EN010147 Registration number 20053829

**1. Answer to question 2.13.8 (deadline 4 August 22<sup>nd</sup>, 2025)**

**2. Answer to question 2.9.4 for the Deadline 4 August 22<sup>nd</sup>, 2025**

Title  
 Landscape, Ecology and Amenities Plan

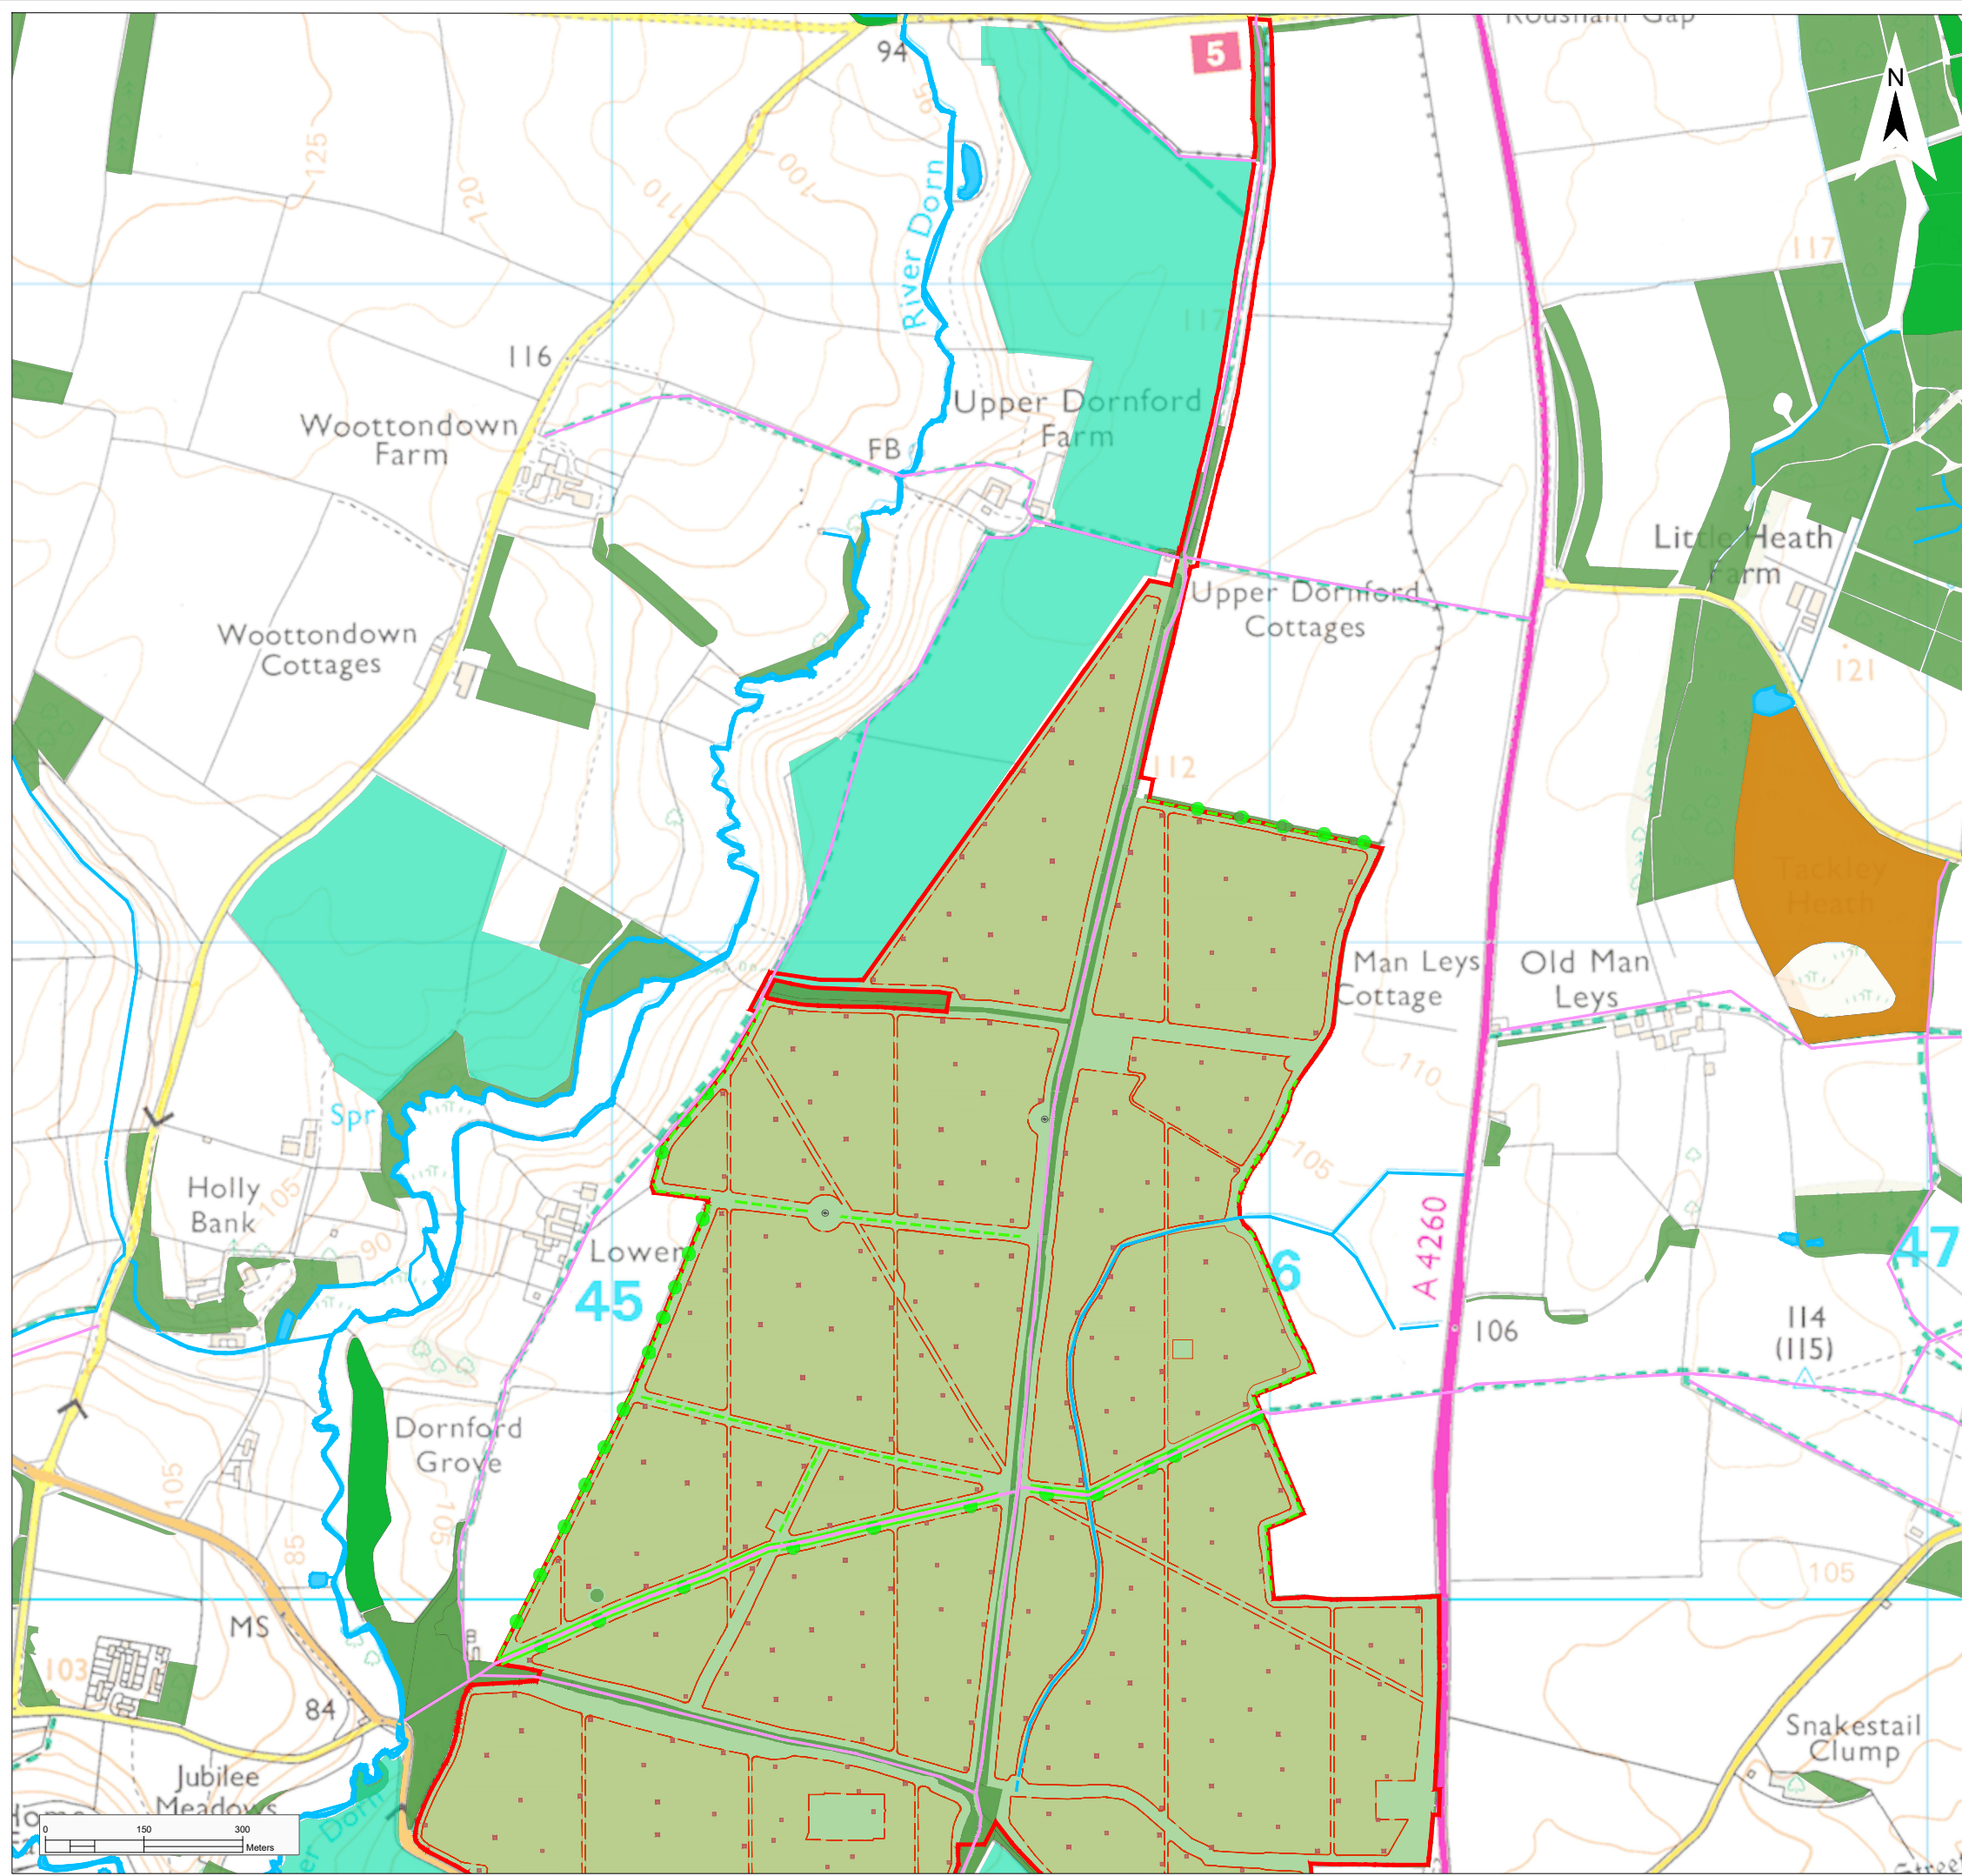
The proposed 'mitigations and benefits' on the map APP\_7.3.3 - Landscape, Ecology + Amenities Plan (AS-022 in the Examination Library, shows a sketchy detail of what the Applicant envisions to provide around the periphery of our property, [REDACTED] We do not accept being surrounded on three sides by a cycle path located immediately close to the edges of our garden; it would result in a serious infringement of our privacy. Furthermore, the design of this cycle path is flawed and potentially dangerous as the path crosses Lower Road twice from its west side to the east and back. Lower Road is a busy, narrow country road carrying thousands of cars and HGVs in each direction every day. Even a primary school child working towards the school project would not endorse a cycling path crossing this road.

Moreover, as stated in our earlier correspondence, we do not wish any landscape amenity mitigation in the form of hedgerows or trees to be planted for our benefit near the border of our property.

Considering that the proposed solar installation will surround our property on three sides and overwhelm our visual amenity in all directions up to the horizon line in many viewpoints, we request that any buffer zone be at least 85 meters from the boundaries of our property and not 25 meters; and be applied on all three sides. We understand that an 85 metre buffer zone may have been accepted for other properties impacted by the development. Finally, we reiterate that the proposed land for solar panels west of the river Evenlode is ALC ~85% (and almost 100% of the land between the ~120 metre frontage of our property and the river Evenlode is ALC grade 1 and 2). Solar panels should not be placed on this grade 1 and 2 land and the best way of mitigating the blight of solar panels in this area would be to remove them totally.
